site plan as proposed scale 1 : 200 @ A3

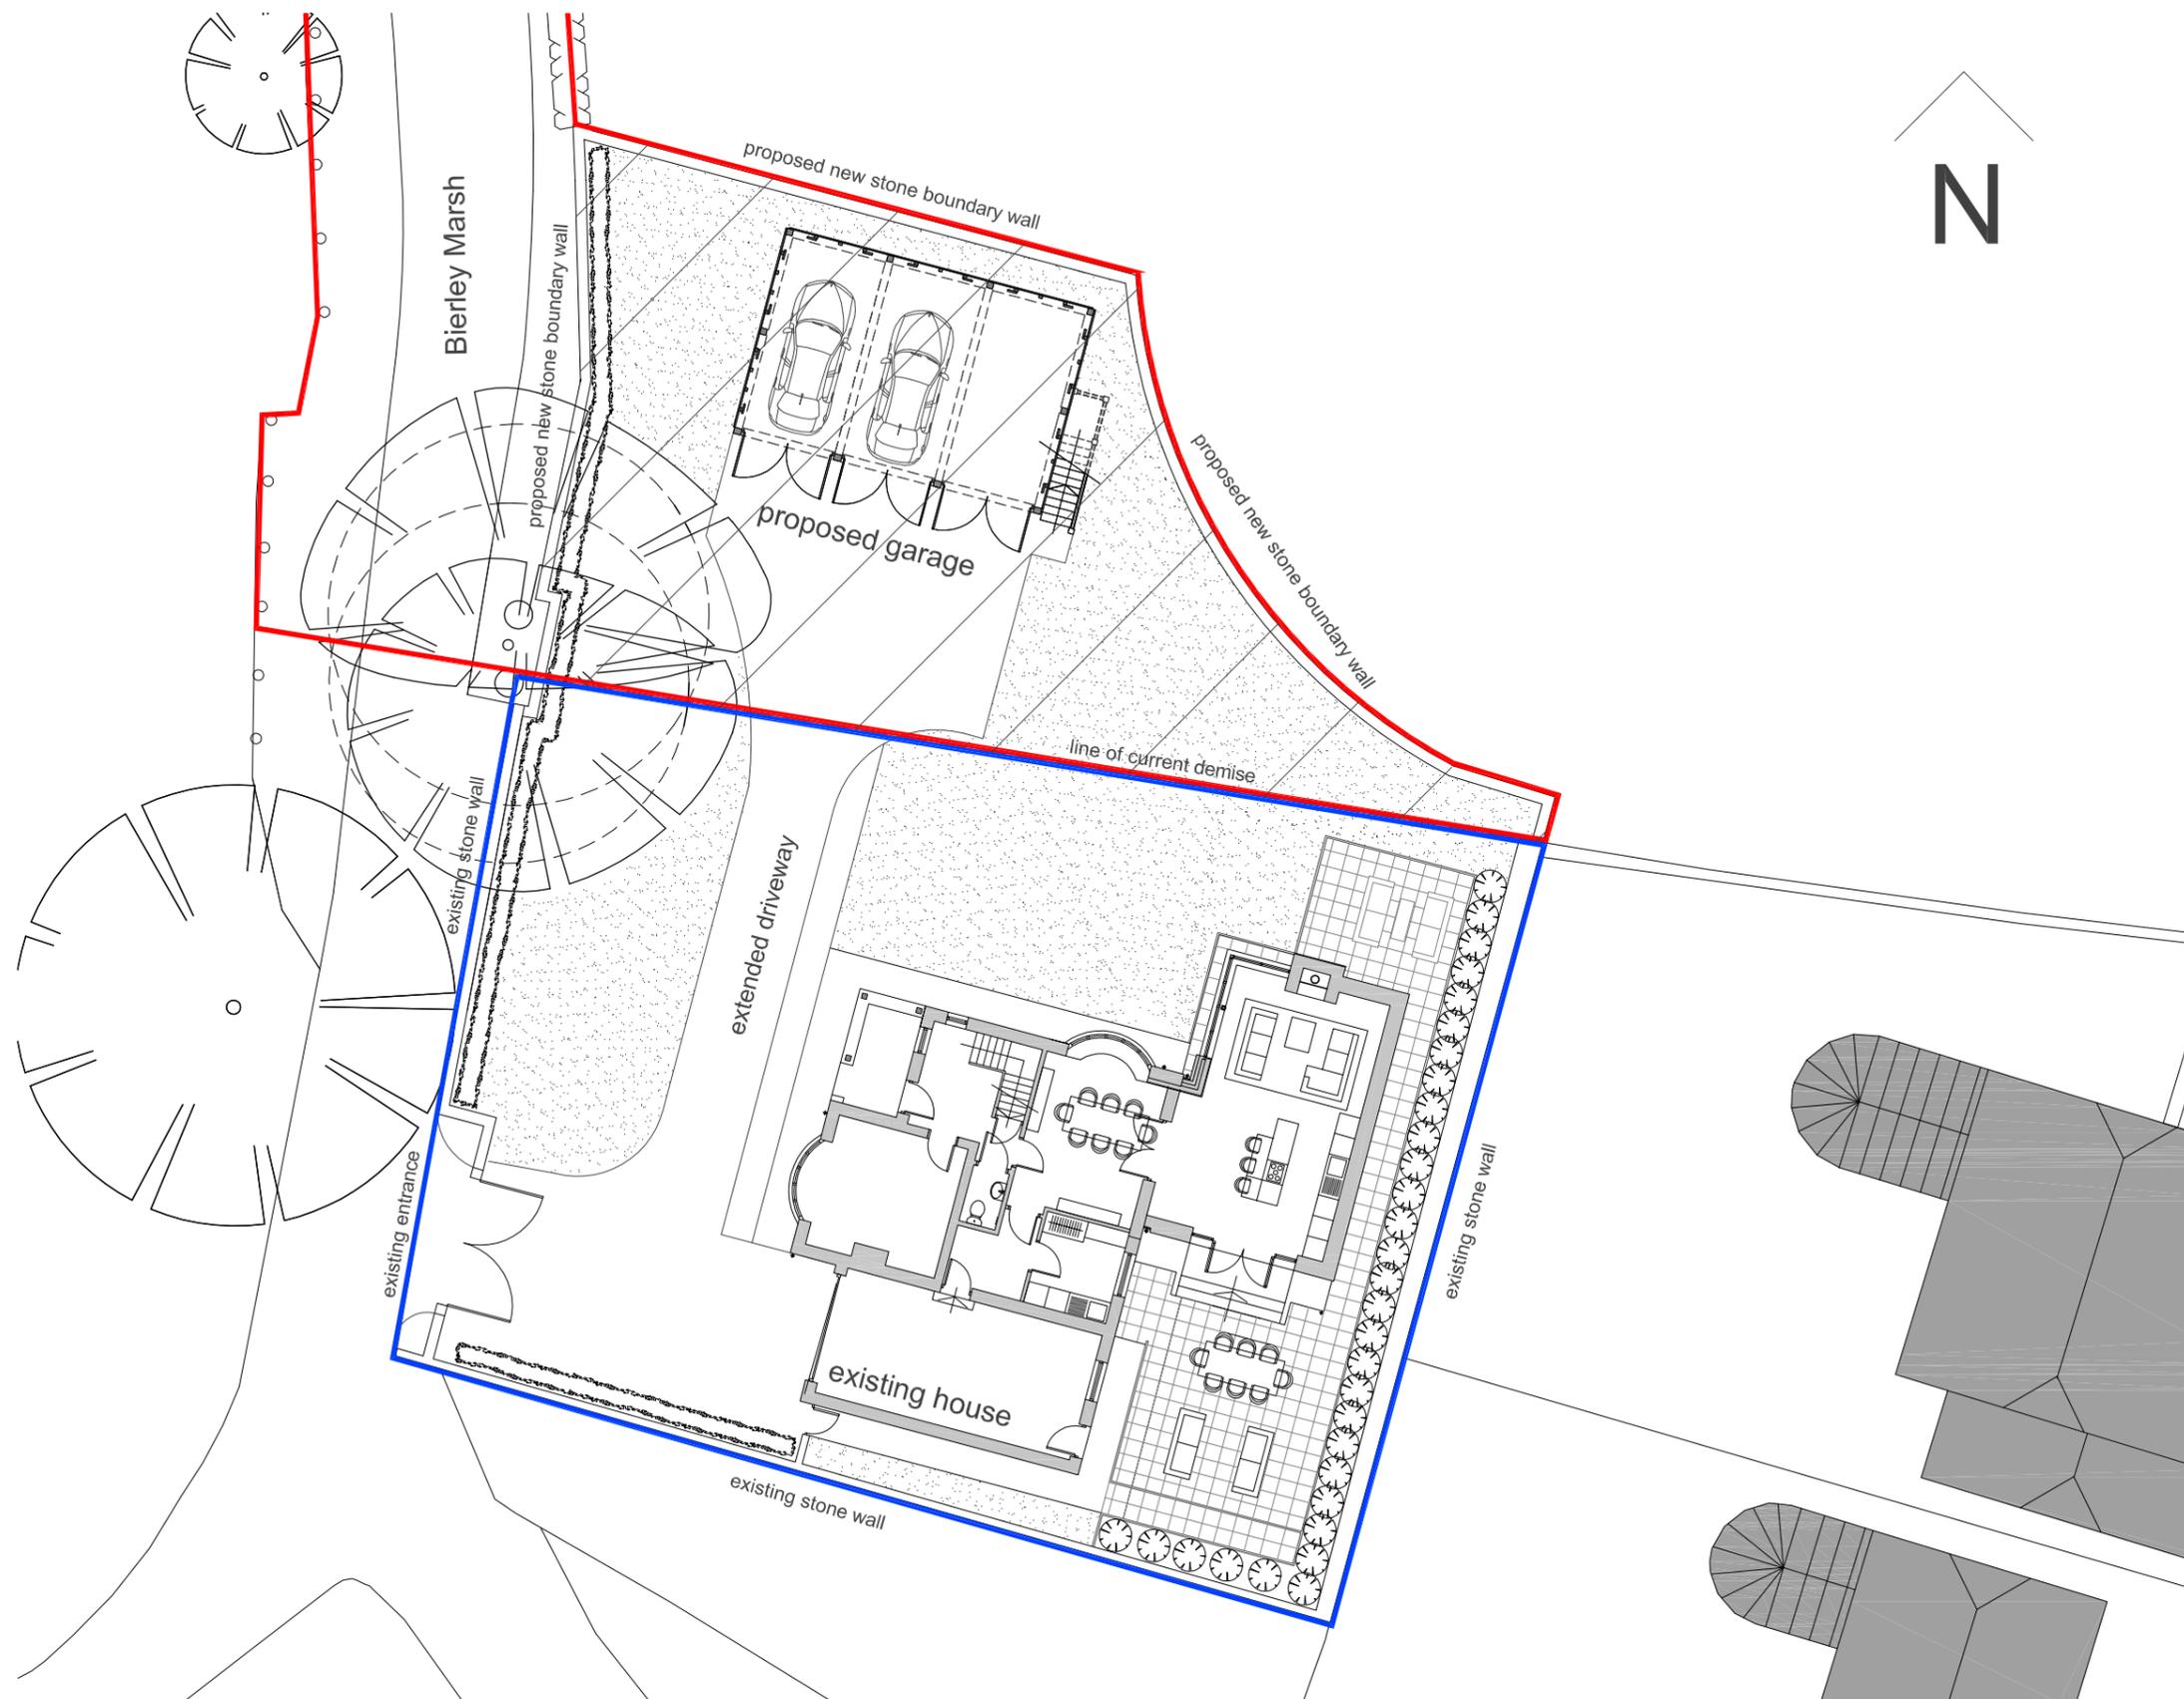
What is also clear is that the applicant is showing the red-line boundary encroaching up to 3m onto common land.

I have challenged as to whether the applicant has necessary approvals and consents, required under the Commons Act 2006, to use common land in his scheme. Driving over the common and parking in this location, and other locations along Bierley Marsh, is illegal. The edge of Common is highlighted, in green on the plan, below.

Above plans also show a small verge to the north of the boundary wall to Cross Gables. It therefore now seems odd that the applicant is fencing in this land.

I ask, if any necessary approvals, that may be required (TBC) for fencing, in this location, are not in place, that appropriate Enforcement action be taken, regarding this fence line.
